DECISION DELEGATED TO DEVELOPMENT MANAGER

Application No: H13-0218-19 **Applicant:** Mr Matthew Naylor
Proposal: Conversion of agricultural building to residential
Location: Vickers Farm Washway Road Moulton Marsh
Terminal Date: 1st May 2019

DRAWING NAME:
General Arrangement

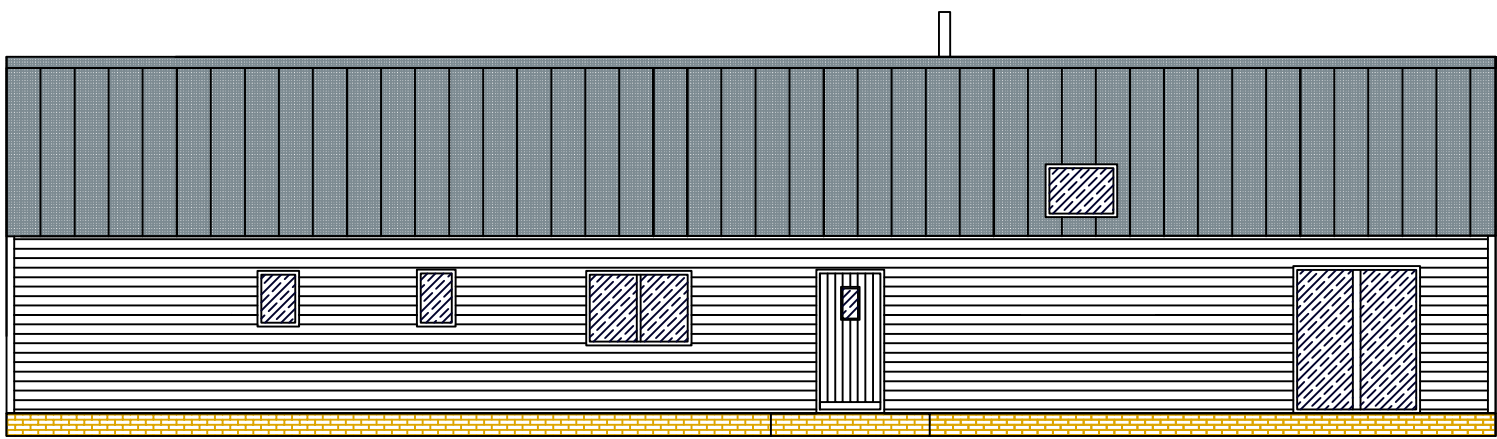
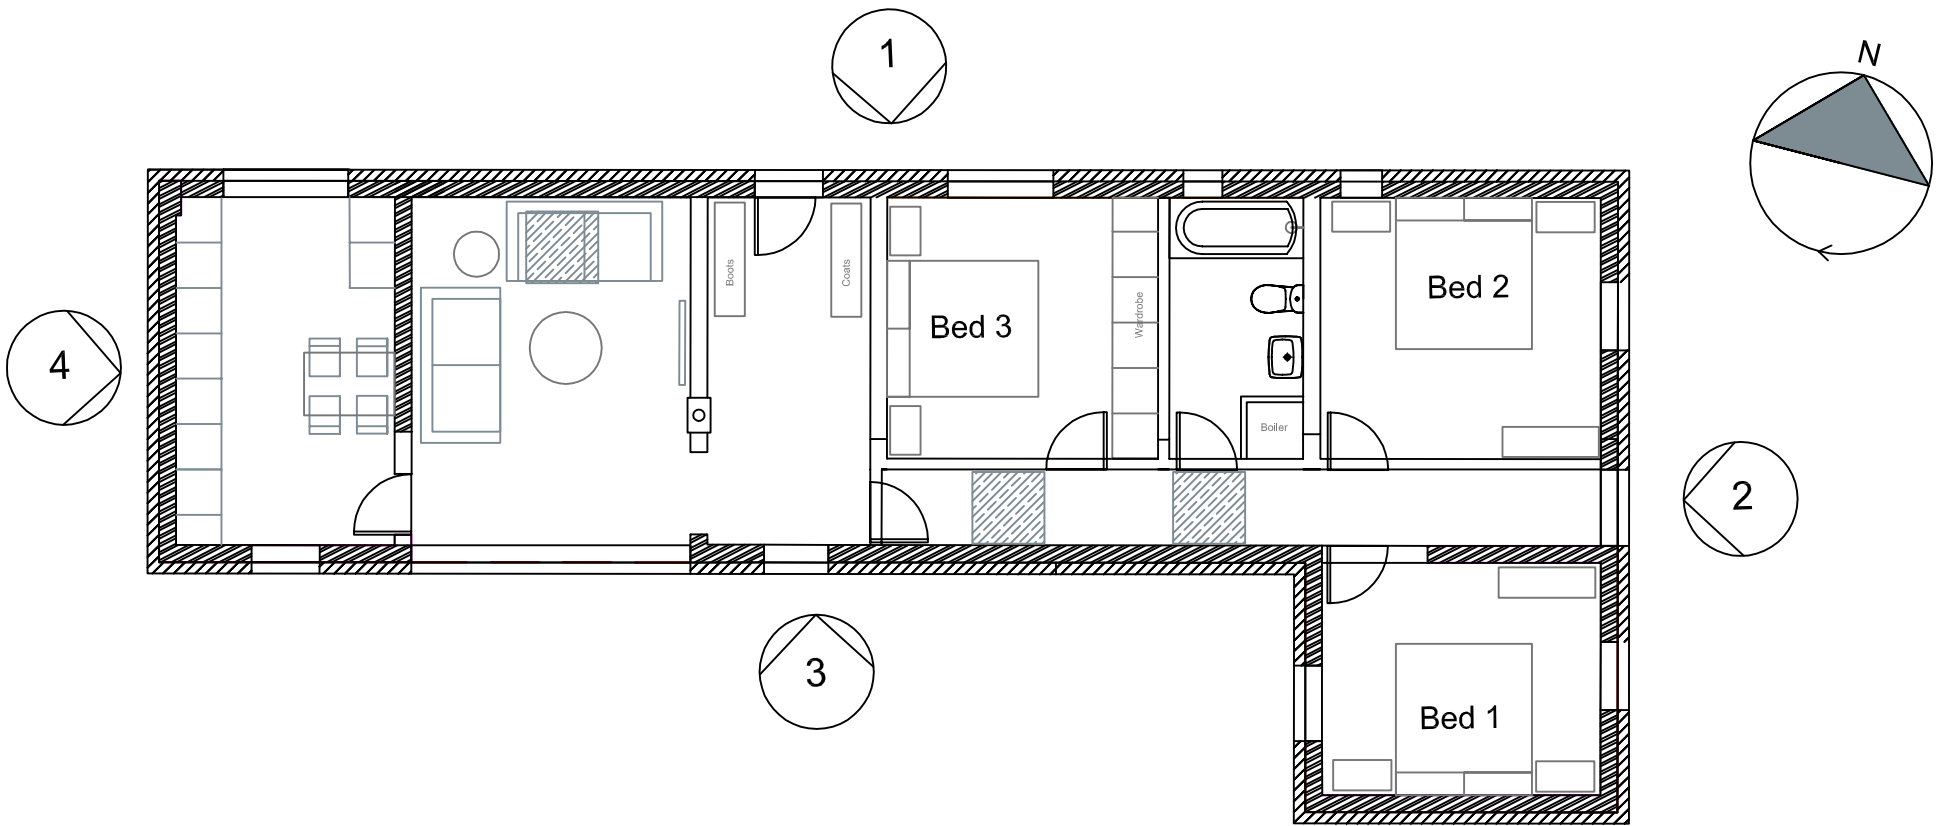
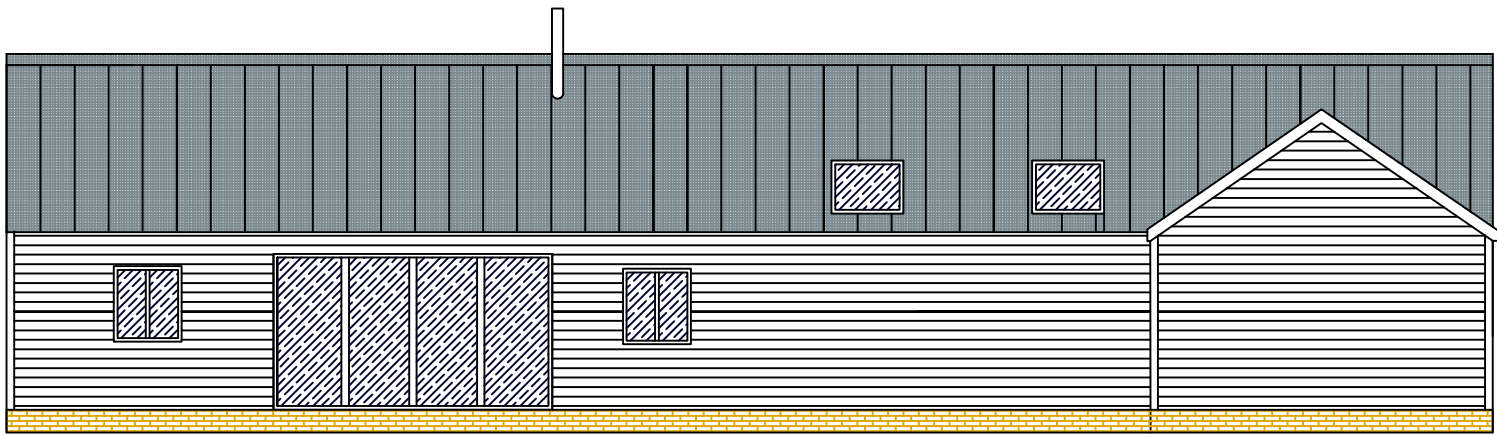
Noise Impacts - The proposal would not materially harm the amenity of neighbouring residents. The application indicates that the building would be insulated to comply with Approved Document Part E - Resistance to the passage of Sound. Windows have not been provided to the West elevation, so as to reduce road noise from affecting the property.
